STATE OF WASHINGTON  
**DEPARTMENT OF ECOLOGY**

December 20, 2023

**RE: SV-23-00001**

Thank you for the opportunity to comment on the Notice of Application process for the Horish Shoreline Variance. The Department of Ecology (Ecology) has the following comments.

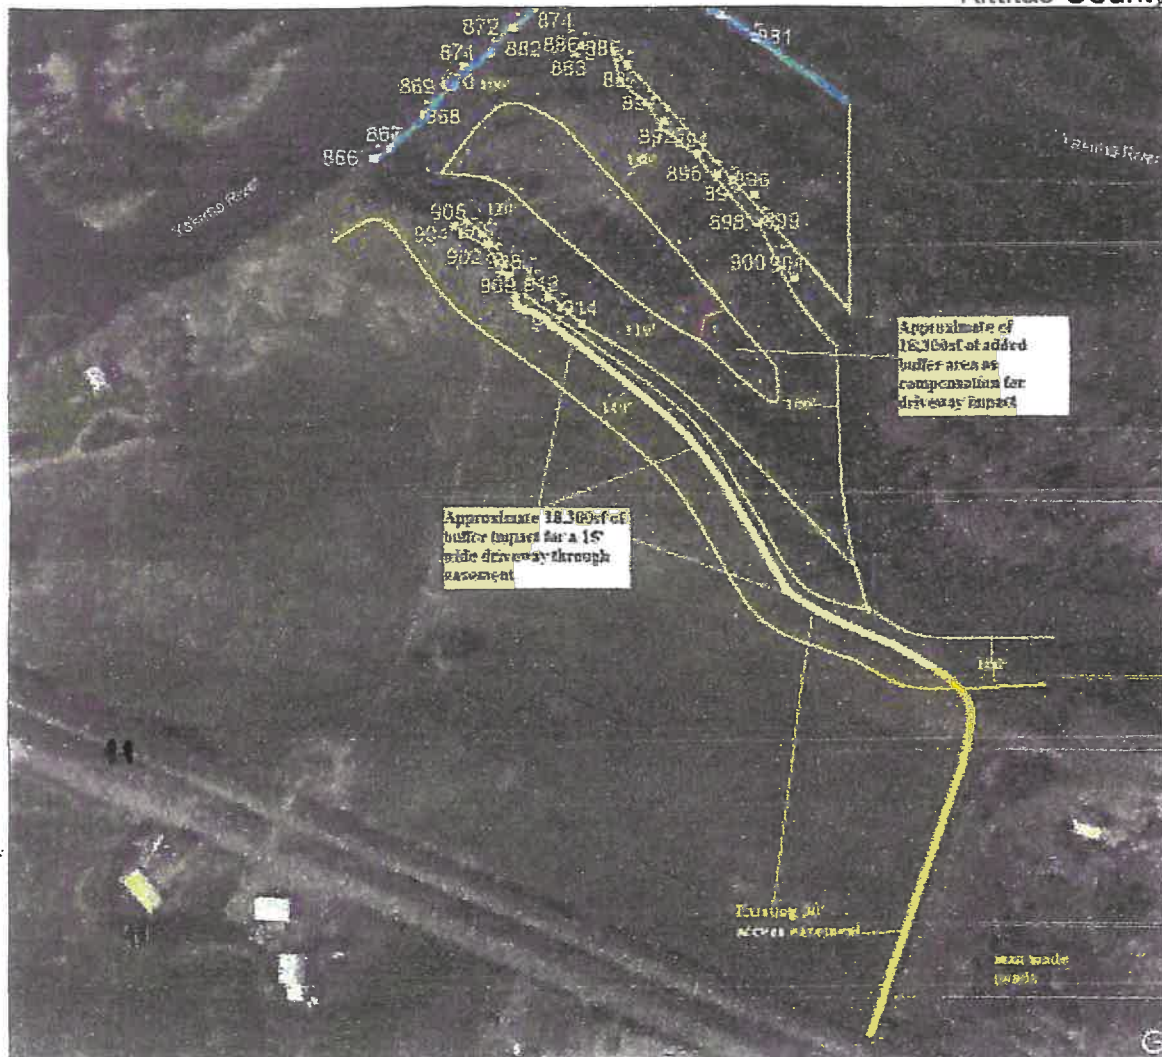
The new driveway constitutes development proposed to replace existing access to parcel 516534. Documents supporting the Boundary Line Adjustment of parcel 546534 show that an existing driveway provides access to the potential building site noted in the application. This existing driveway provides access to the site with minimal disturbance to the shoreline and shoreline wetland buffers.

The proposed driveway increases disturbance to the shoreline environment and shoreline wetland buffer.

While the application may satisfy some of the criteria provided by WAC 173-27-170, it does not appear that a variance is necessary in order for the applicant to have access to their property. Access can be obtained via the existing easement. Abandonment of the existing easement would occur through the applicant's own actions. Additionally, there is ample space on the parcel to construct a driveway outside of shoreline jurisdiction, wetland buffers, and other areas. Also, the applicant owns the adjacent parcel, which may allow access to the property as well. So, the application does not meet the following criteria:

WAC 173-27-180 provides a list of material necessary for a complete application. On the June 2, 2023 site visit and notes following that up, several alternatives to driveway alignment were discussed. The application should provide a site plan that shows these alternatives as part of a complete application.
